17 March 2020

**Re: Response to Mangoola Coal Continued Operations Project (SSD-8642)
Request for Additional Information dated 17 February 2020**

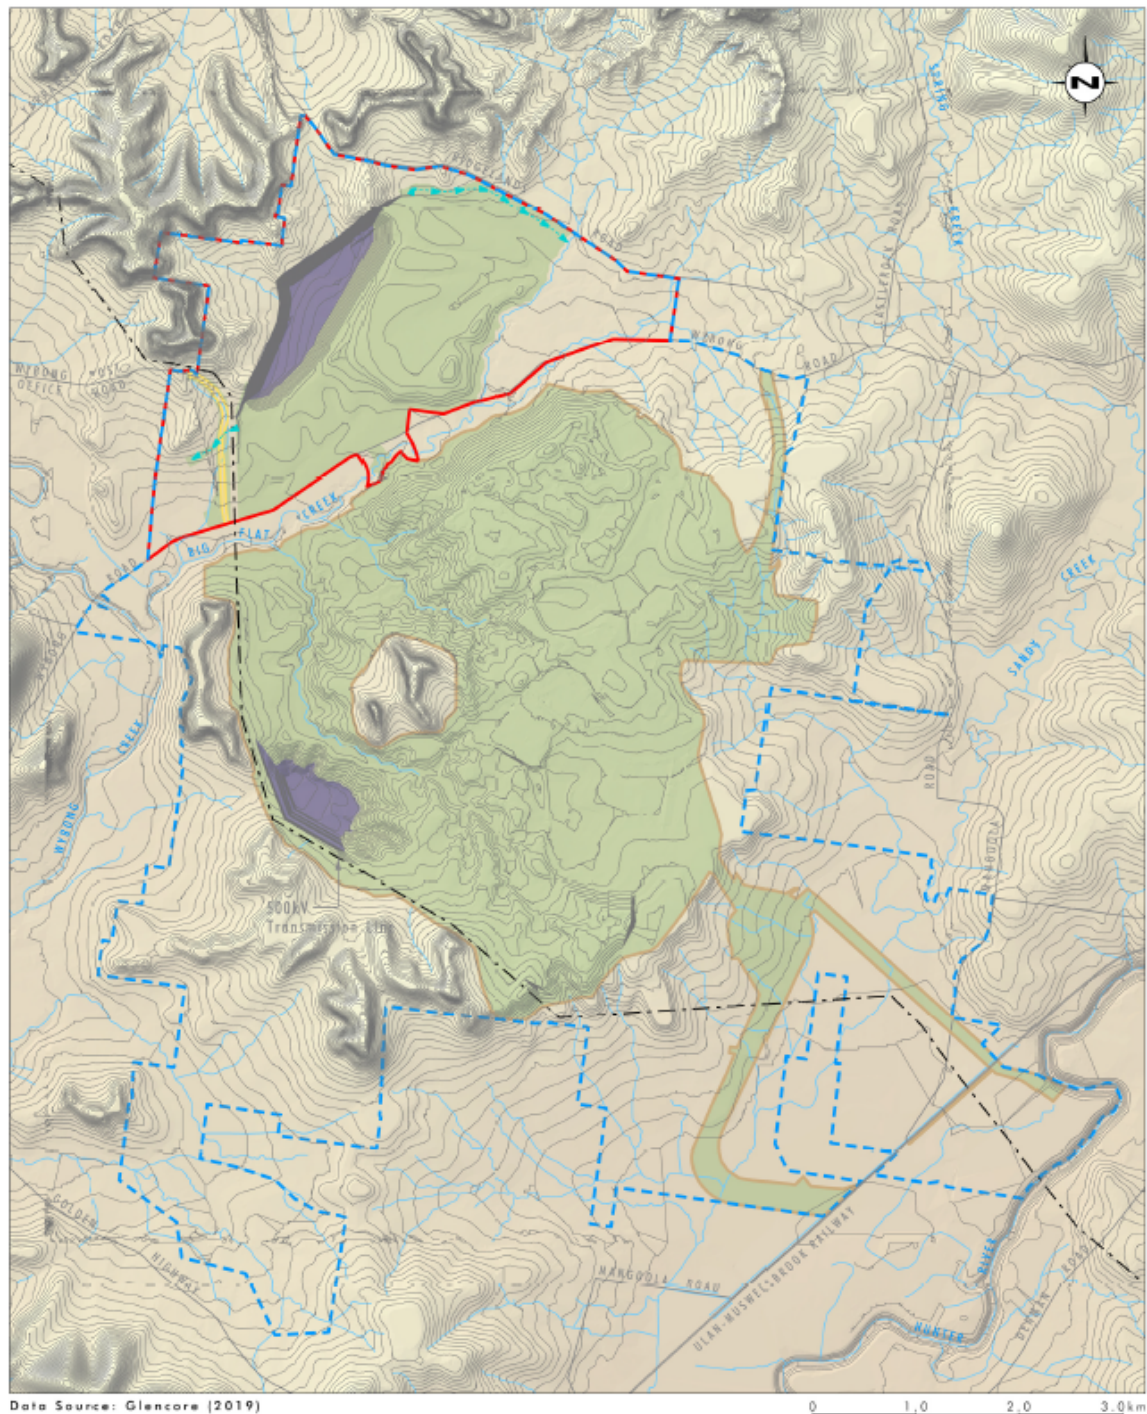
- The level of detail provided in the Environmental Impact Statement and Response to Submissions is not consistent between each considered final landform. The independent review has considered economic, mine feasibility / engineering and broad environmental outcomes to further justify the preferred final landform (case 3). The financial implications and surface disturbance area of each option has broadly been described. The Resources Regulator does not consider sufficient information has been provided to discount differing case options. For example, case option 6 (partial backfilling of each void) has been cited as resulting in a larger surface area affected by the final void, however whether sustainable rehabilitation outcomes may have been increased / decreased such as increased land use opportunities and potentially enhanced landform/ geotechnical stability have not been articulated for each discounted option. As such, the Resources Regulator cannot comment on the appropriateness of the preferred final landform. The Resources Regulator would recommend that at minimum, further information is provided for landform case option 6 (partial backfilling of each void) and case option 4 (one final void in the north).

As presented in the MCCO Project RTS, the independent review (IEMA 2020) concluded that Case 3, as presented in the MCCO Project EIS and Mine Plan Options Report (Appendix 2 of the EIS), represents an appropriate outcome which demonstrates that Mangoola has considered the balance between delivering an economic mine plan whilst giving proper regard to leaving beneficial post mining land uses and minimising final voids. Further, the review found that Mangoola has demonstrated through the rehabilitation already completed at the existing Mangoola Coal Mine that it has been able to successfully design and construct the natural style landforms along with the revegetation techniques that are proposed in the MCCO Project EIS.

In response to the request from the Resources Regulator further information in the form of a comparison between the Case 3 (MCCO Project), Case 4 (one void in the north) and Case 6 (partial backfill) landform is provided below. An overview of the case options including the proposed strategy, time and cost required to achieve each case option is provided in **Table 2**. Further detail is available within the Mine Plan Options Report (Appendix 2 of the EIS).

Case 3 remains the mine plan for which approval is being sought. Mangoola consider that Case 3 represents a balanced outcome which achieves economic expectations for the MCCO Project whilst also improving the overall shape and total area of the two proposed final voids. Additionally, the overall visual amenity and usability of land, in terms of achieving a self-sustaining native ecosystem post mining land use, is improved in Case 3 (in comparison to Case 4 and Case 6) due to availability of overburden material for enhanced landform design.
